**From:** Jeff Tarling  
**To:** Jean Fraser  
**Date:** 2/24/2014 4:52 PM  
**Subject:** RE: Rockland Ave Outfall

>>> Jean Fraser 2/24/2014 2:07 PM >>>  
Lauren

This is not your issue, but the RTI info is not great and still being reviewed by DPS and therefore I would like to be sure that the neighbors and Portland Trails are on board, and have a final proposals plan (referenced in the approval letter) showing the surface/landscape (final location of Portland Trail and paved/graveled areas) that clearly shows the minimal nature of the changes in the area not covered by the Landscape Plan.

C-201

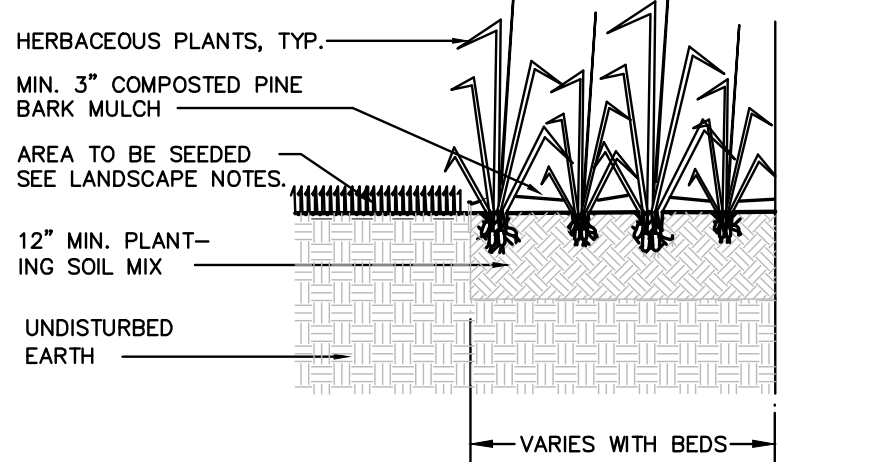
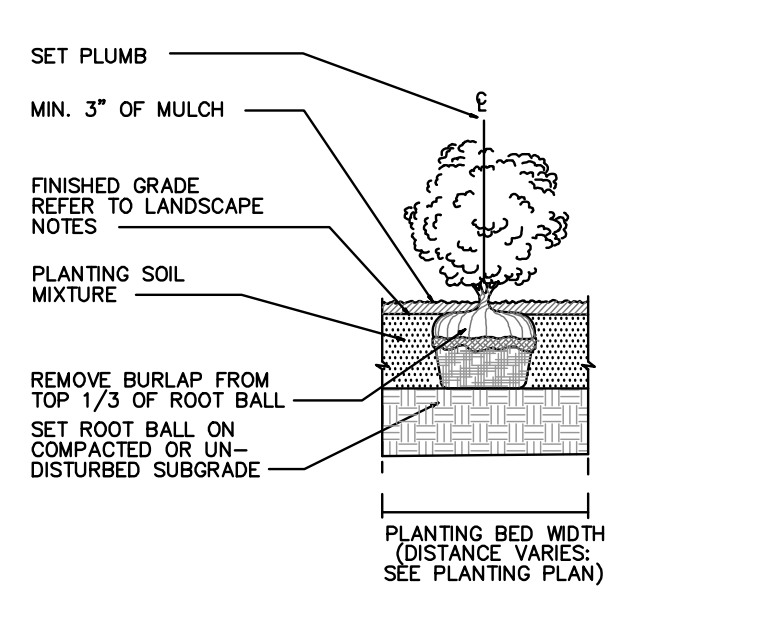
"That the applicant shall introduce additional planting in the vicinity of the maintenance access way, as determined by the City Arborist, after the treatment unit and maintenance access way are complete and the scope and need for such planting is clarified".

For the plans you attached, sheet C-201 is the landscaping plan. The rendering pdf was a visual representation created for use at some of the public meetings, and is not intended to serve as an official landscaping plan.
